December 6, 2023

**RE: Bank of Oklahoma – 6301 Jefferson  
Grading and Drainage Plans  
Engineer's Stamp Date: 08/25/23  
Hydrology File: E17D016C**

Based upon the information provided in your submittal received 11/29/2023, the Grading & Drainage Plan is **not** approved for Building Permit. The following comments need to be addressed for approval of the above referenced project:

OVERALL GRADING &
DRAINAGE PLAN

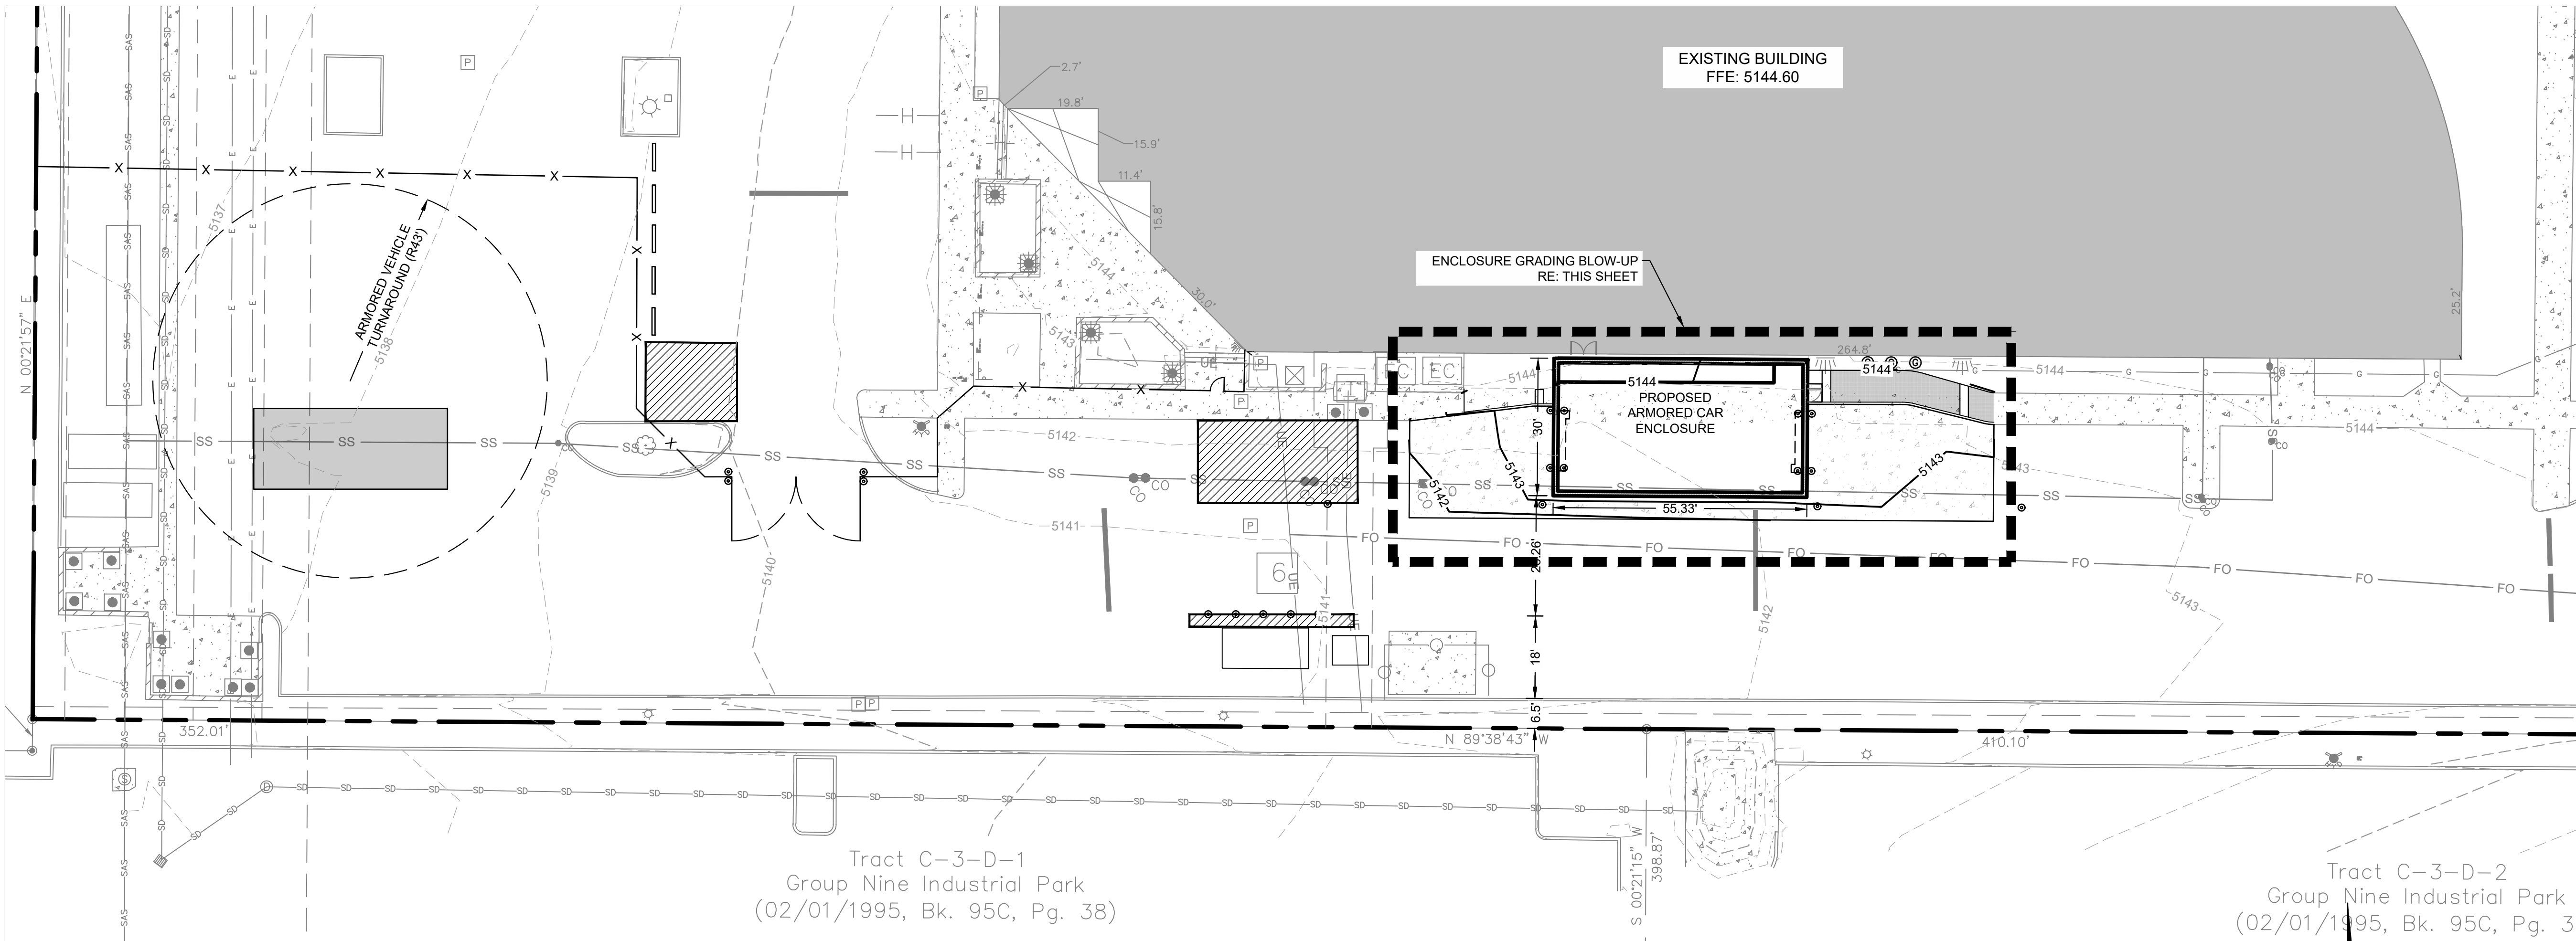
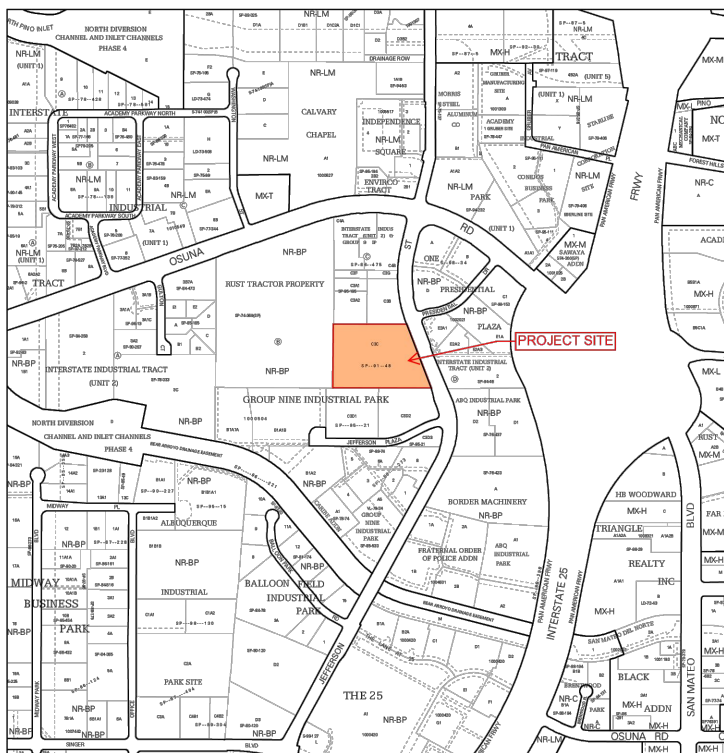
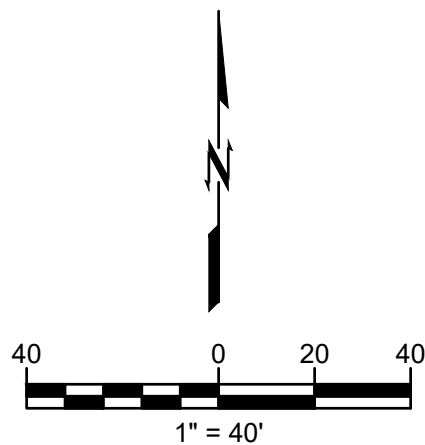
1. Per the DPM, the following must be on the Grading Plan. Please note the Grading Plan must be a stand-alone construction document.
  - a. Please provide a Vicinity Map. Typically, this is the Zone Atlas. This can be downloaded in pdf format from the City of Albuquerque's website.

- b. Please provide the Benchmark information (location, description and elevation) for the survey contour information provided.
  - c. Please provide the FIRM Map and flood plain note with effective date.

- d. Please provide a legal Description of the property.
2. Please place all the topographic information that CSI provided on the overall Grading & Drainage Plan. Then the second sheet can be the closeup view of the proposed building. (C500) Please show the existing finish floor of the building to be 5144.6' on the plans. These are the only two that Hydrology needs to approve.

5. Since this site is a redevelopment and there is no room to provide the required volume, I would suggest removing the pond and filling out the attached Waiver of Management Onsite for the Stormwater Quality Volume (SWQV).
6. Please add a note which states, "The Owner has elected to pay the Payment in Lieu for the required Stormwater Quality Volume. The Payment in Lieu Amount = XXX CF x \$8/CF = \$ XXX.00".
